RE: Winrock Town Center – Phase A- RED ROBBIN (J19D058B)
Grading Plan, Engineer's Stamp Date: 4-26-2016

Based upon the information provided in your submittal received 4-21-16, the above referenced plan is approved for Building Permit with the following comment:

TITLE:  
PHASE A - RED ROBIN GRADING PLAN

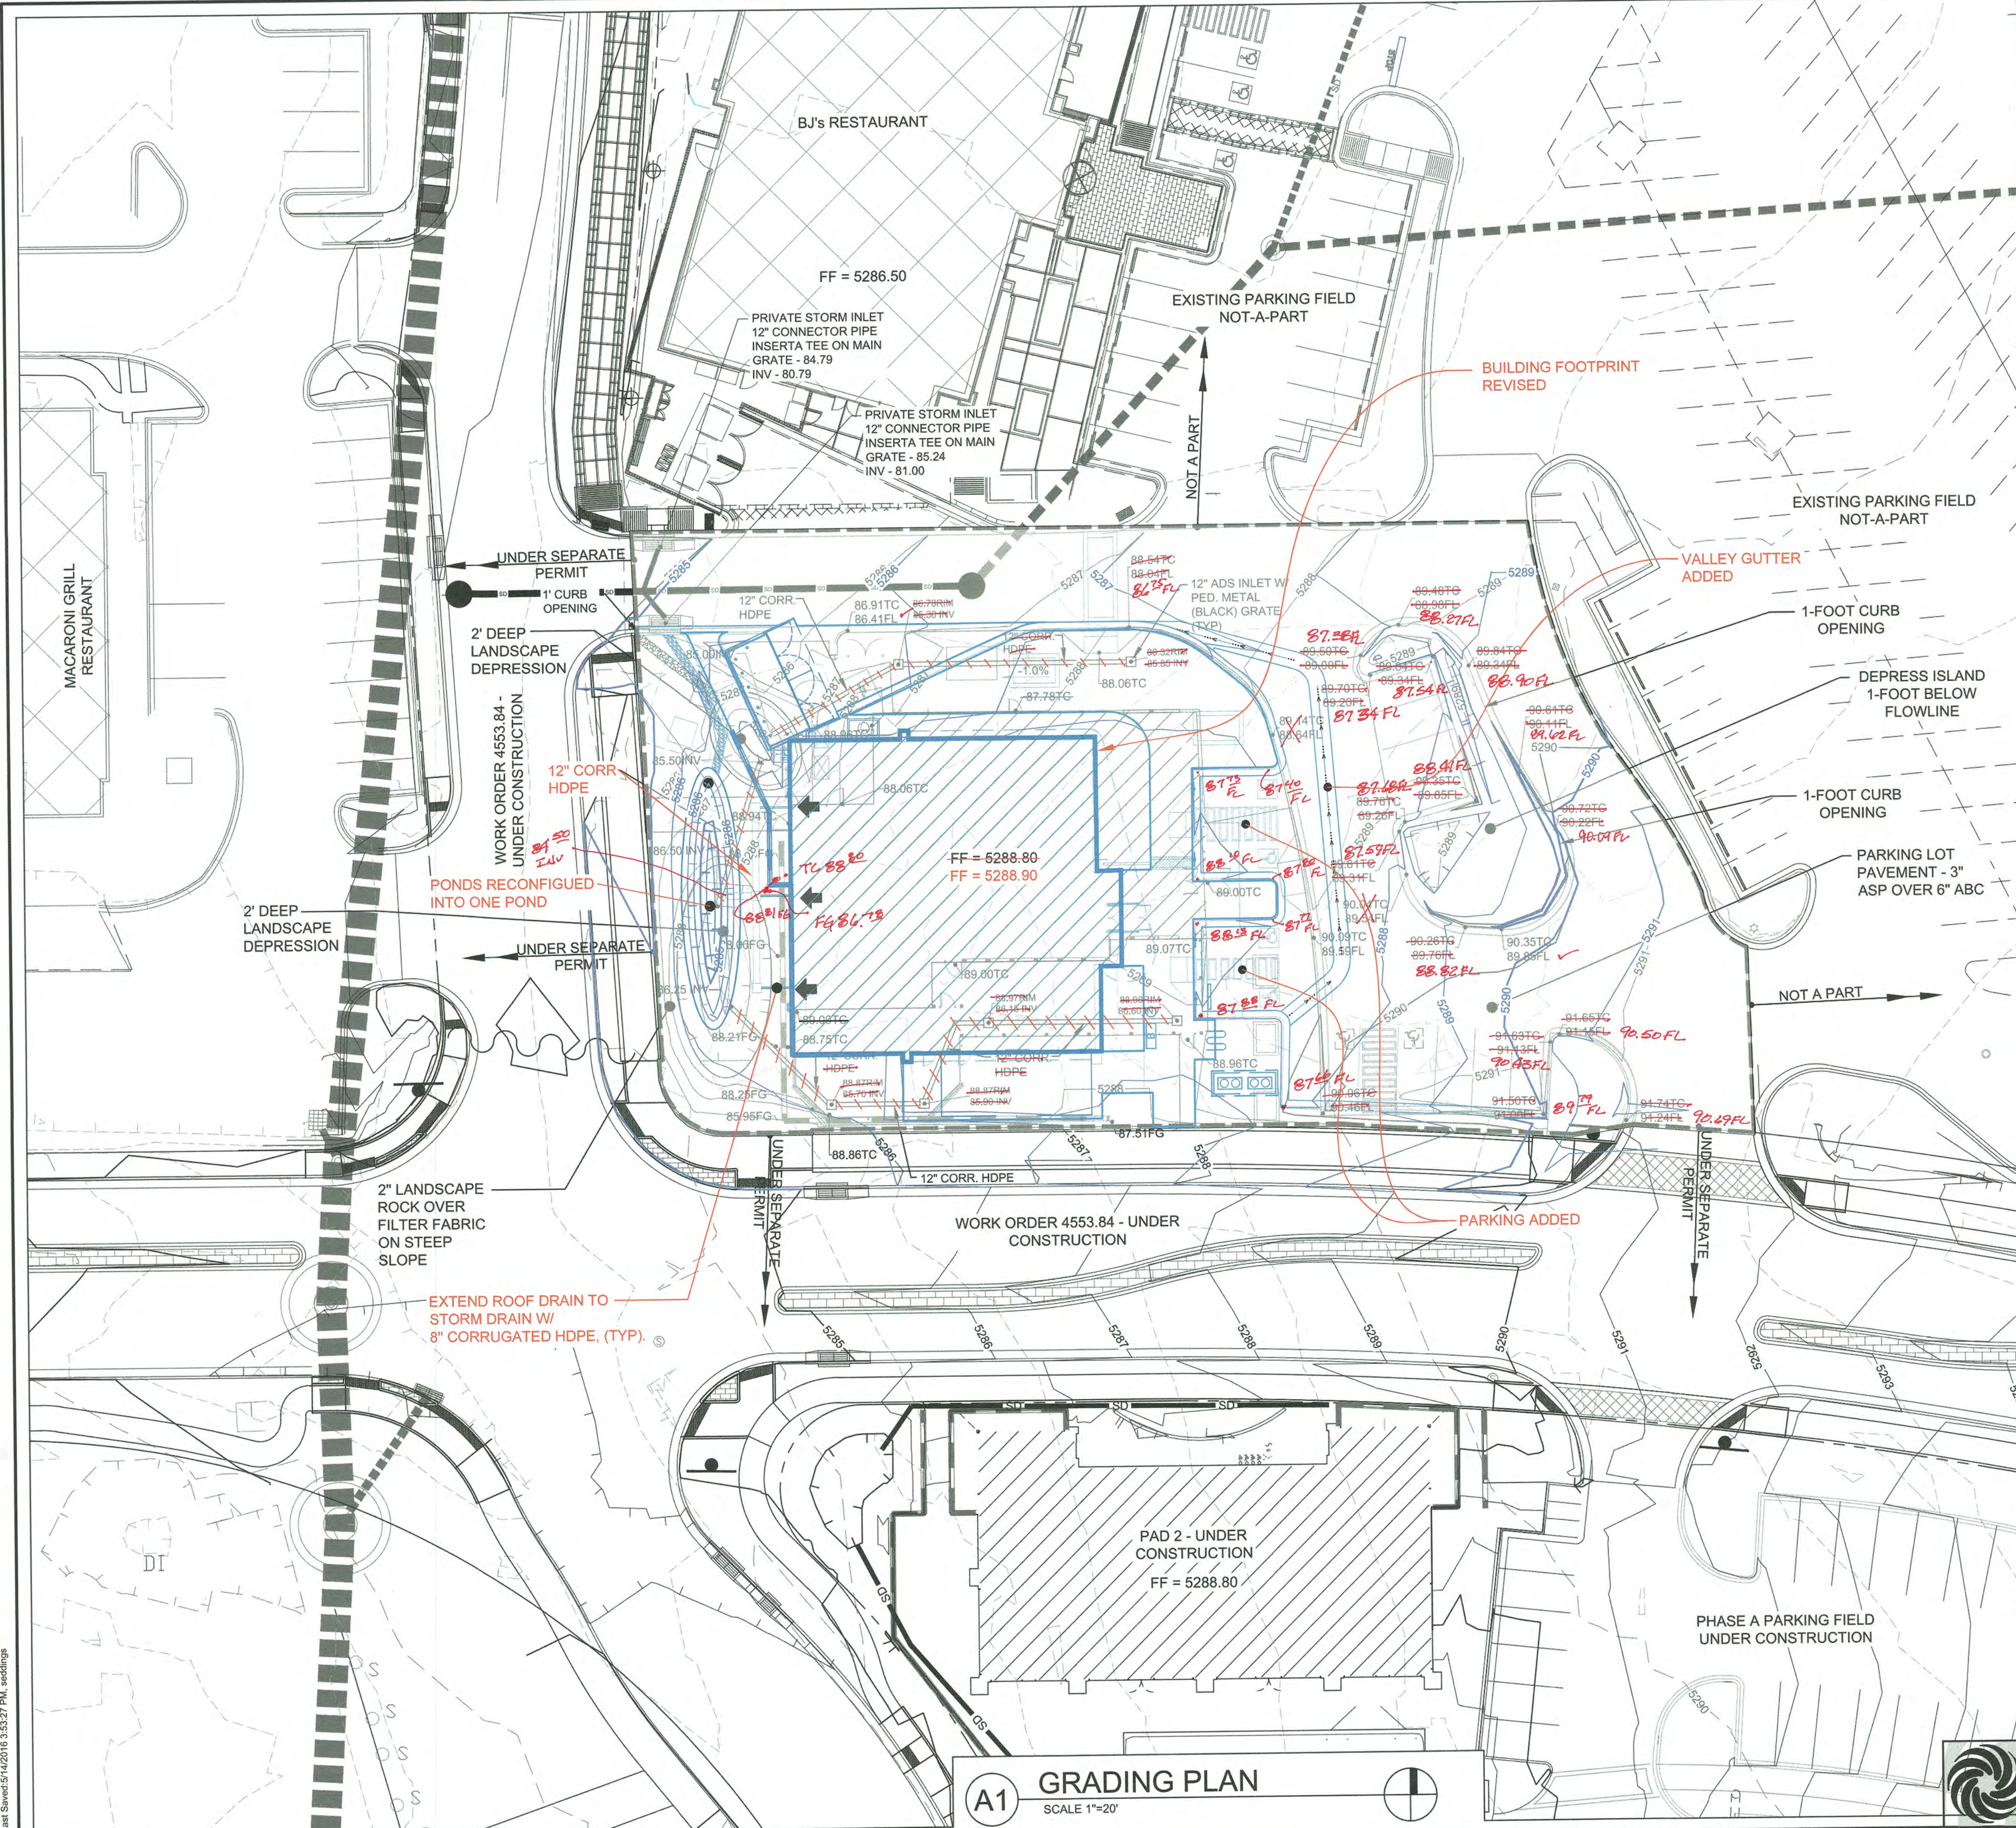
- It is preferable that the pond at NE corner of site discharges to inlet at NE corner. If this can be changed during construction, note so on the as-built plan.
